March 20, 2023

**RE: Wells Park Subdivision- Vacation of Rosemont Ave. Right-Of-Way
Response to Sketch Plat Comments (PS-2021-00129-Sketch Plat)**

SUBJECT: Sketch Plat

PUBLIC ROW VACATION
 AND PUBLIC AND PRIVATE
 EASEMENT VACATION
 EXHIBIT

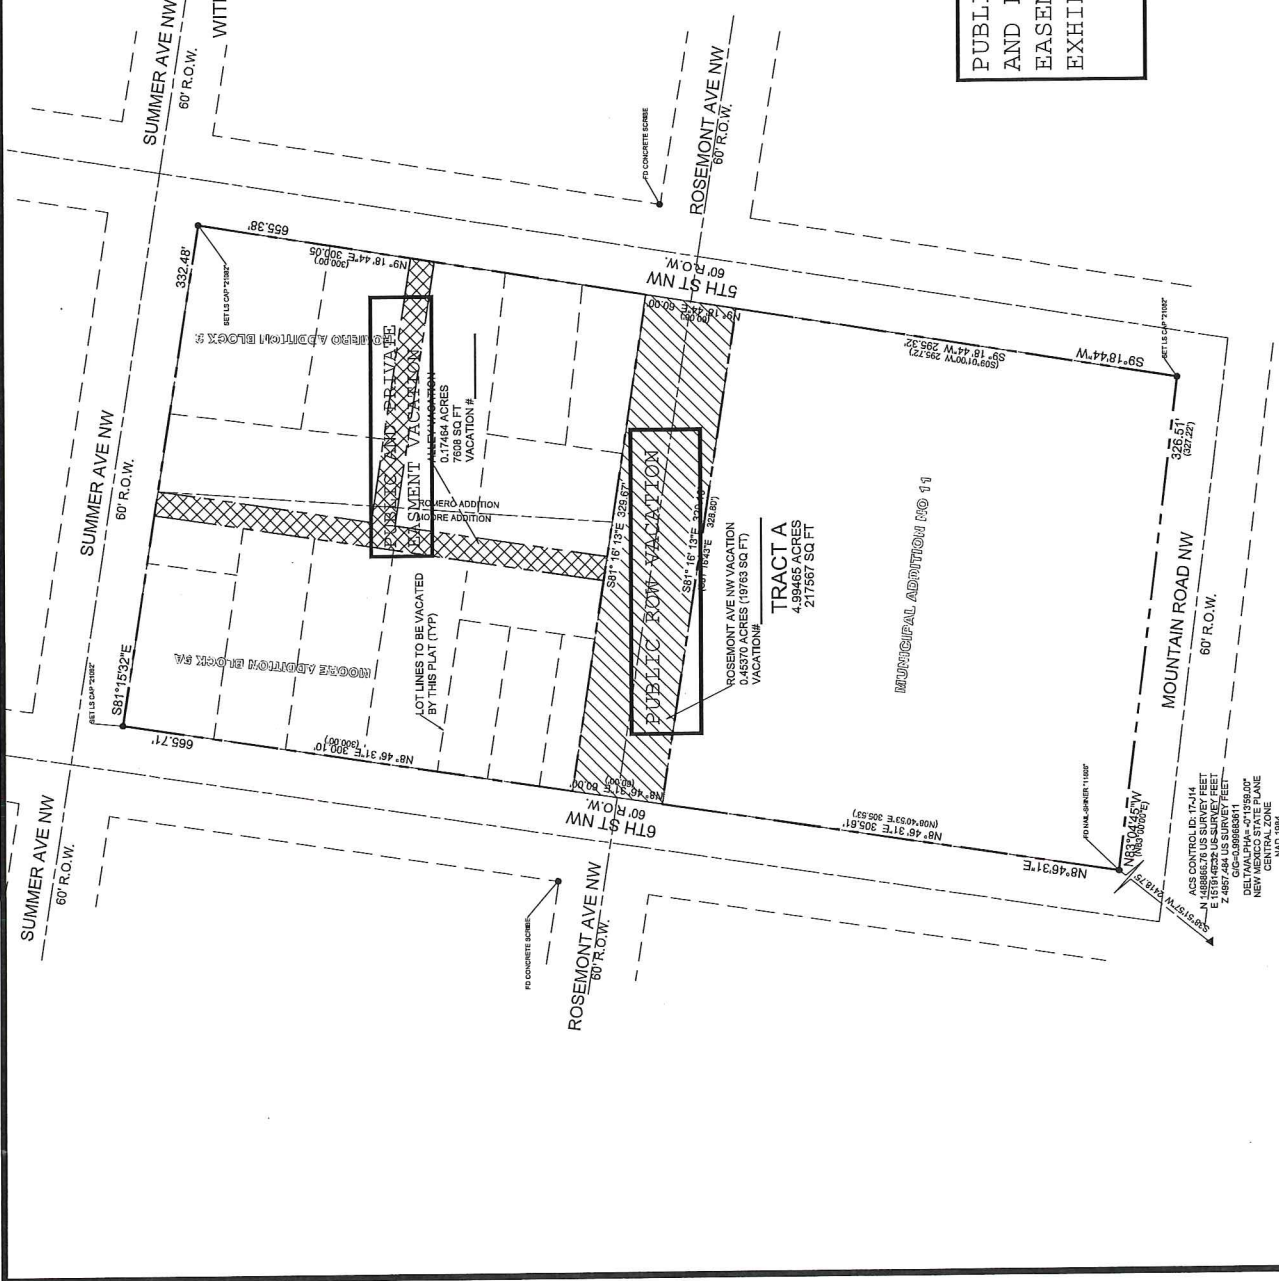
- Comment #1** Concurrence by adjacent property owners.
Response All properties along the boundary of Rosemont Ave. are owned by City of Albuquerque.
- Comment #2** Access from south parcel.

Response The south parcel is owned by the city. Access to the south parcel is accommodated from 5th Street, as is shown on the approved city construction plans “Wells Park Expansion”, city project #568591.

- Comment #3** Required 6 ft. wide sidewalk.
Response All of Rosemont Ave. is proposed to be removed and disposed, including sidewalk and curb and gutter. No sidewalk is proposed in this area. The vacated right-of-way is proposed to be incorporated into the new consolidation plat of approximately 4.99 acres.
However, 6 ft. wide sidewalk is proposed for 5th Street, 6th Street, Mountain Road. Summer Road. Only Rosemont Ave. has 4 ft. sidewalk.

1. The proposed vacation would need written concurrence from all property owners along the vacated roadway. If approved by DRB, the vacation would then need to be approved by COA Council.

~~2.~~ 2. The proposed vacation of Rosemont will adversely impact the access from the parcel to the south of Rosemont. What coordination has been done with this property owner, and how is their access proposed to be changed?

3. Sidewalk is required to be a minimum of 6 feet along the site. Please label existing sidewalk widths.
